**KIRKLEES METROPOLITAN COUNCIL
INVESTMENT & REGENERATION SERVICE**

DELEGATED DECISION TO DETERMINE PLANNING APPLICATIONS

Reference No:	2023/62/92541/E
Site Address:	Sandhurst Court, 7, Spen View, Dewsbury Moor, Dewsbury, WF13 3PZ
Description:	Erection of detached garden room
Recommending Officer:	Elenya Jackson

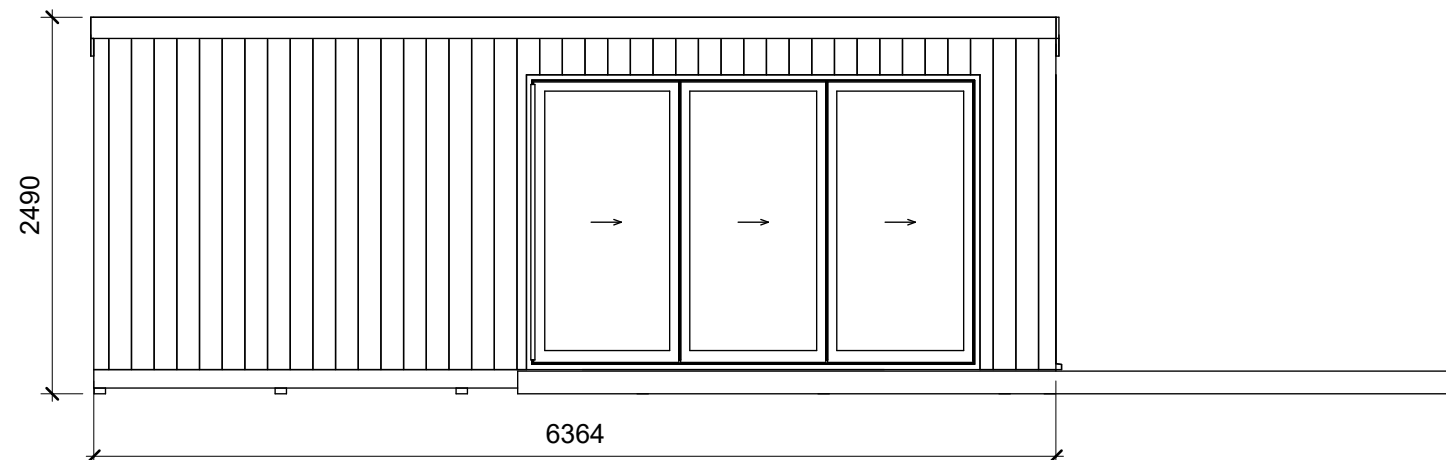
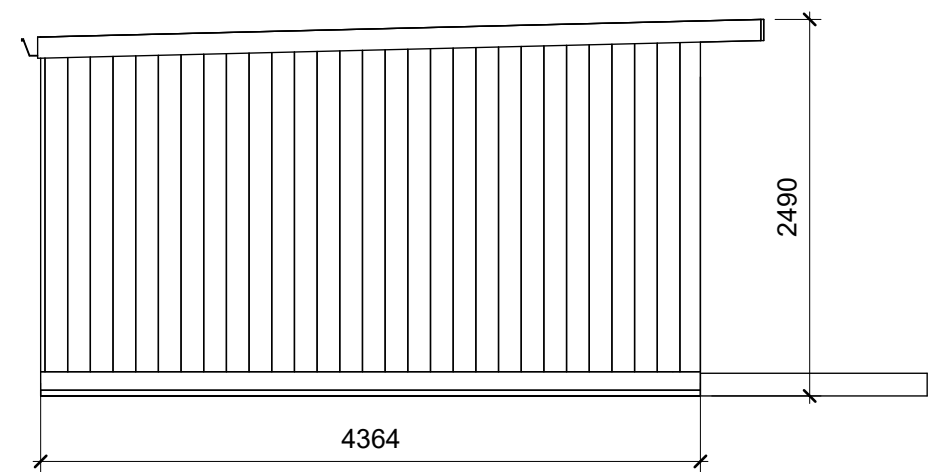
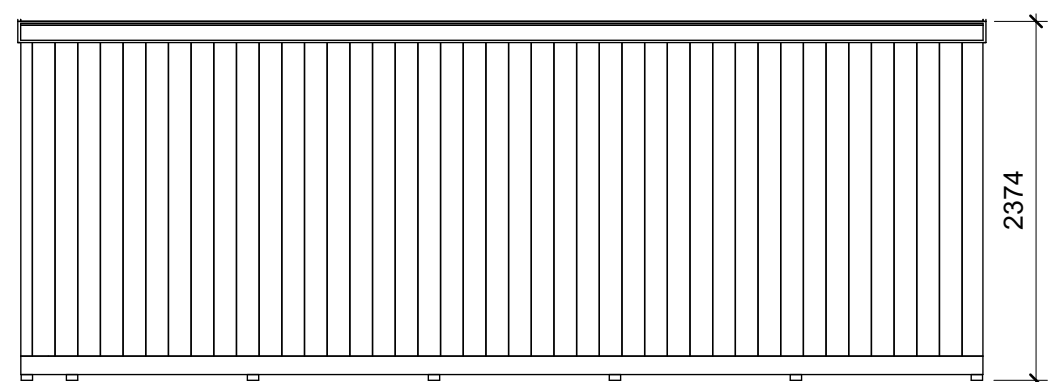
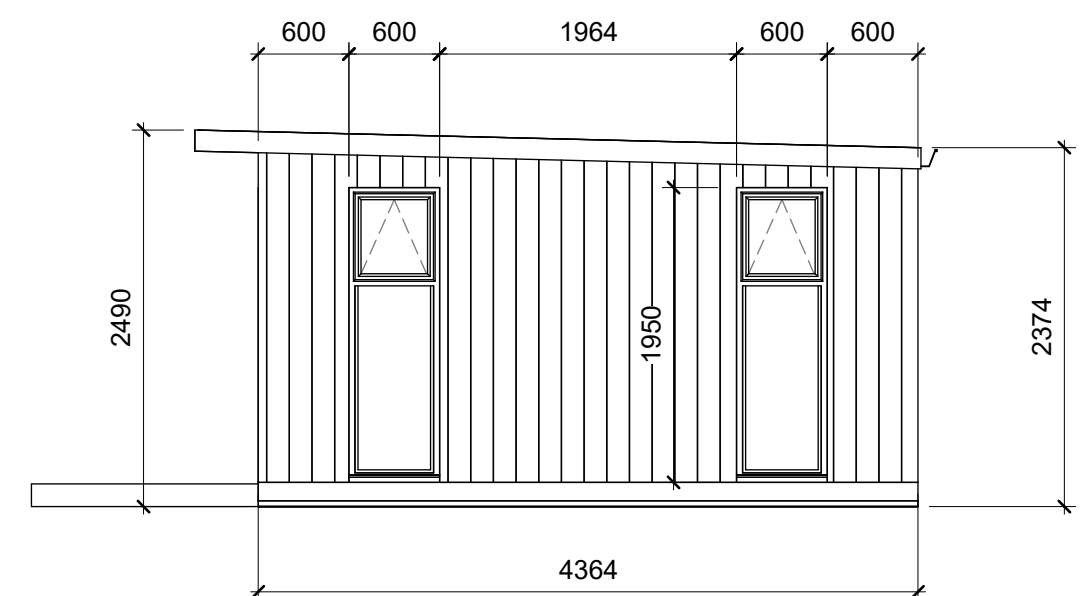
The garden room is proposed to have a-symmetric roof which reduces in height towards the southern boundary of the site (matching the site's topography), a width of 4.4m and a depth of 6.2m.

The outbuilding would have a maximum height of 2.5m and be finished in timber cladding with grey upvc windows.

The existing site is red brick which would not be replicated in the garden room; however, the use of timber cladding is considered a contemporary addition which would be appropriate in a garden setting.

Overlooking: The proposal would not feature any rear facing windows

Site Plan @ 1:500

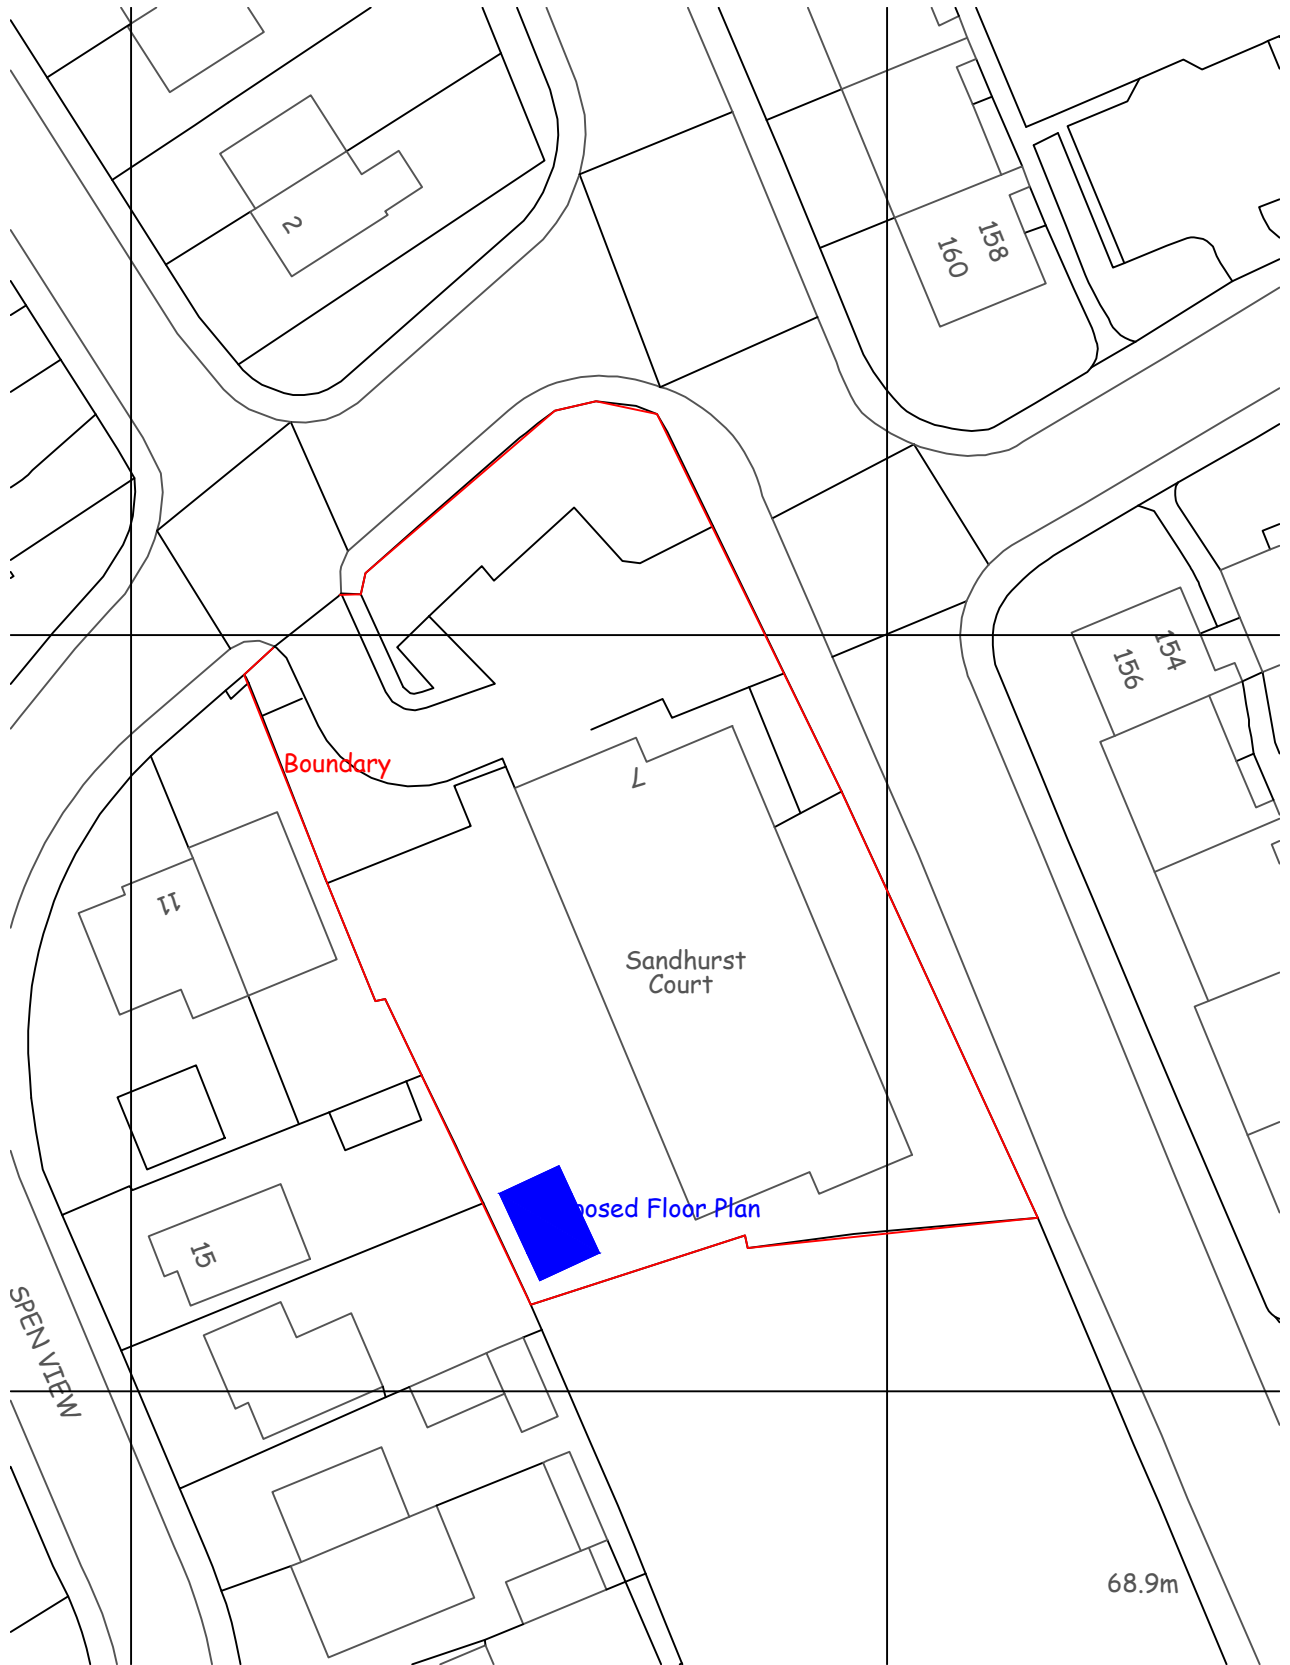
Overshadowing/loss of light: The proposal would be situated 1.7m away from the shared boundary and 12m away from the rear elevation of no.17. It is considered that due to the single storey nature of the proposal, the separation distance would be sufficient to not raise any significant issues regarding overshadowing/loss of light/overbearing impact.
